M42 Junction 6 Development Consent Order Scheme Number TR010027

8.56 Applicant's Comments on any additional information or submissions received by Deadline 3

**Applicant's Comments on any additional information or submissions
received by Deadline 3**

Drawing Title
FIGURE 12.1 NOISE LOCATION PLAN

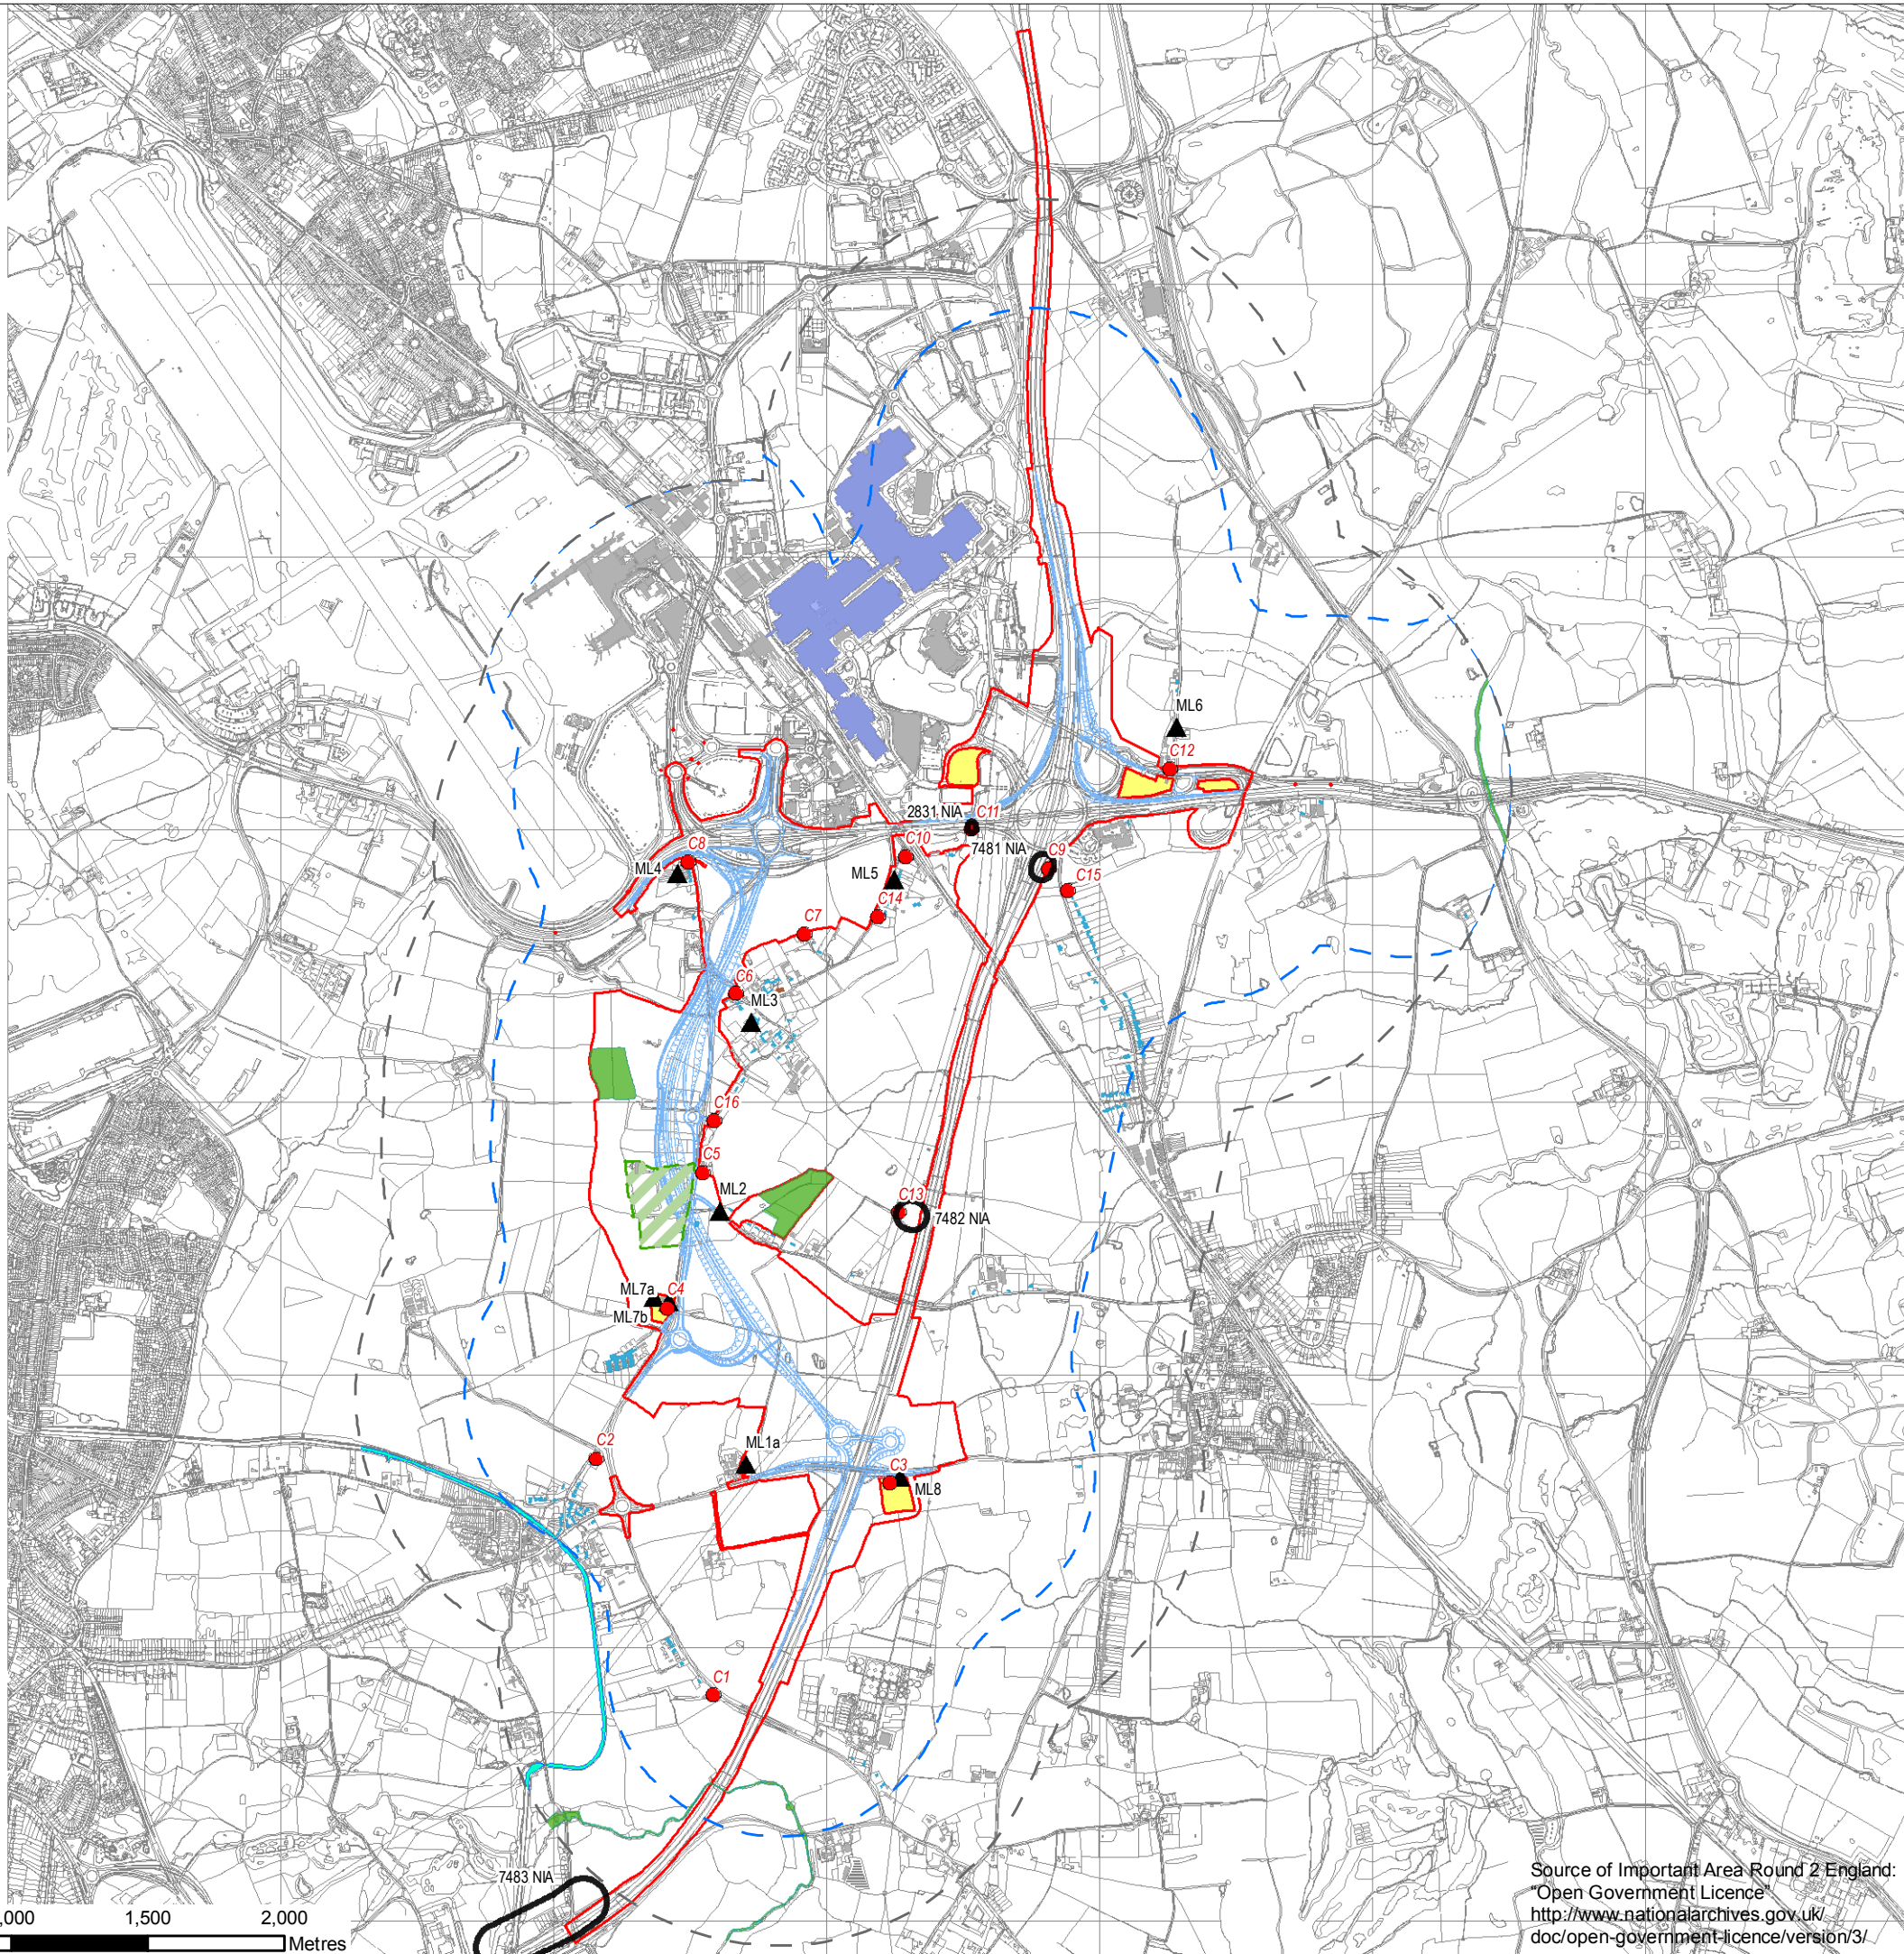
Submitted by	Title	Comments
Church Farm Accommodation	Re-alignment of Catherine-de-Barnes 1	<p>3. Church Farm Accommodation Comment:</p> <p>The proposed re-routing of the Catherine-de-Barnes lane will bring the existing traffic closer to our property (from approximately 140m away to 60m away) and, coupled with the removal of our existing boundary (due to compulsory purchase), will open up our property and business to the re-routed road and the subsequent increased traffic noise and pollution. This road will be at ground level so therefore the noise will be significant during the construction and when in use. The closest point to the proposed road is the guest rooms utilised by the business. The Catherine-de-Barnes road is a very busy highway which will back onto the existing paddock where we graze the horses, bringing it approximately 80m closer to my property. Coupled with the all the noise of constructing the bridge and the road itself, it leaves me with very serious concerns as to whether I will be able to continue running my two businesses. Appendix 1 shows a number of views from our guest rooms which will be impacted by the proposed works and also the proximity of our horses to the area of compulsory purchase. We enquired at the planning meeting, held on the 30/05/19 with Highways England and local residents, what the purpose of the road indicated on the plan that ran behind our boundary was and Jonathan Pizzey advised that this was only a maintenance road to an underground drainage tank - but less than a week later we received a plan showing the re-routed CDB lane and compound access highlighted in this exact space (one of a number of examples where information has been withheld by Highways England).</p> <p>The Applicant's Response:</p> <p><u>Construction Phase</u></p> <p>Chapter 12 of the Environmental Statement (ES) [APP-057/Volume 6.1] presents the construction noise assessment for the Scheme. This identified that during construction of the Scheme, the areas identified in Table 12.17 of Chapter 12 of the ES would benefit from localised solid site hoarding (barriers). The representative receptor considered most applicable to Church Farm Accommodation is C6 Rose Cottage, which is located on St Peter's Lane (see Figure 12.1 within</p>

Submitted by	Title	Comments
		<p>Volume 2 of the ES [APP-101/Volume 6.2]). The construction noise assessment concluded that barriers would likely be required at this location to reduce construction related noise effects.</p> <p>Table 12.7 of Chapter 12 of the ES [APP-057/Volume 6.1] presents the predicted noise levels associated with the construction of Catherine-de-Barnes North Overbridge (activity 2) and the new mainline link road (activity 30). The construction assessment identified potential for significant adverse effects during construction, based upon the risk that the construction activities could result in exceedances of the Significant Observed Adverse Effect Level (SOAEL) for ten or more days in any 15, or more than 40 days in any six months.</p> <p>Notwithstanding the above, the Contractor responsible for building the Scheme will be required to obtain Section 61 consents from the local authority which will place noise limits on construction activities. Any exceedances to the noise levels agreed will be enforceable by the local authority. Furthermore, measures contained within the Applicant's Outline Environmental Management Plan (OEMP) [APP-172/Volume 6.11] will require the Contractor to put in place localised temporary noise barriers to further reduce construction noise.</p> <p><u>Post-Construction/Operation</u></p> <p>In relation to the operational noise impacts of the Scheme, the effects of traffic on the new mainline link road and the realigned Catherine-de-Barnes Lane have been assessed. The new mainline link road will be positioned in an earthwork cutting, which will provide acoustic screening and a reduction in road traffic noise levels. Although the realigned Catherine-de-Barnes Lane will be positioned closer to Church Farm Accommodation, the changes in traffic movements resulting from the Scheme will significantly reduce flows on Catherine-de-Barnes Lane.</p> <p>The operational noise assessment as presented within Chapter 12 of the ES [APP-057/Volume 6.1] predicted that the Scheme will not result in noise effects greater than minor adverse (not significant) in Bickenhill village, and therefore no additional mitigation measures are proposed.</p>
